# CITY OF ALBUQUERQUE

RE: **Jefferson Hotel**  
**Restaurant Ln NE**  
**Grading Plan Stamp Date: 8/15/18**  
**Drainage Report Stamp Date: 8/15/18**  
**Drainage File: F17D044C**

RE: **Jefferson Hotel**  
**Restaurant Ln NE**  
**Grading Plan Stamp Date: 7/30/18**  
**Drainage Report Stamp Date: 7/30/18**  
**Drainage File: F17D044C**

Based on the submittal received on 7/31/18, the grading plan and drainage report cannot be approved for building permit until the following are corrected:

ORIFICE PLATE DETAIL

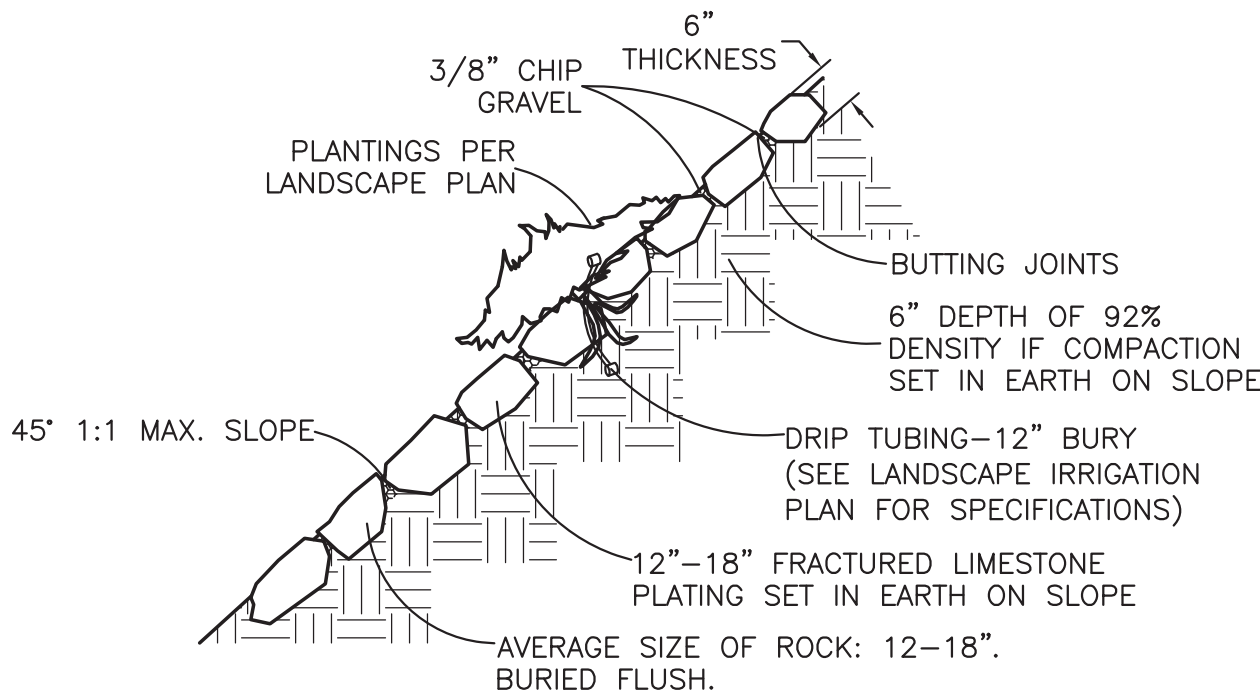
1. Engineer's Certification, per the DPM Chapter 22.7: *Engineer's Certification Checklist For Non-Subdivision* is required.
2. Provide photographs of the installed orifice plate, including one showing its dimensions and include with the drainage certification.

BUILD 1-TYPE D INLET  
PER COA STD DWG #2206  
GRATE=5156.00  
18" HDPE INV OUT=5152.50, INSTALL 9.5" ORIFICE PLATE

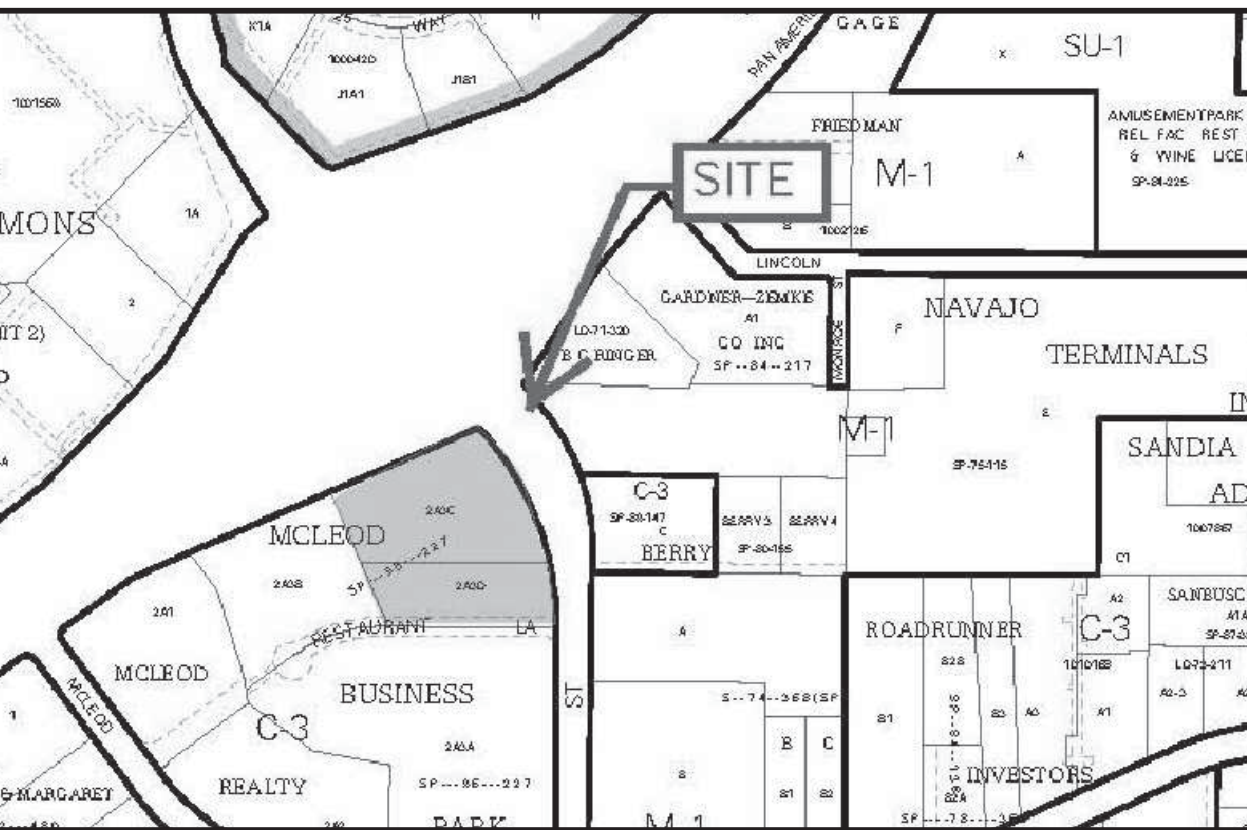
1. The Type C inlet at the NW corner should be removed as it allows surface flows to bypass the first flush pond. Stormwater draining to this low spot will need to be routed to the pond first. Also the 4" orifice plate isn't necessary on this outlet:

CORRECTED
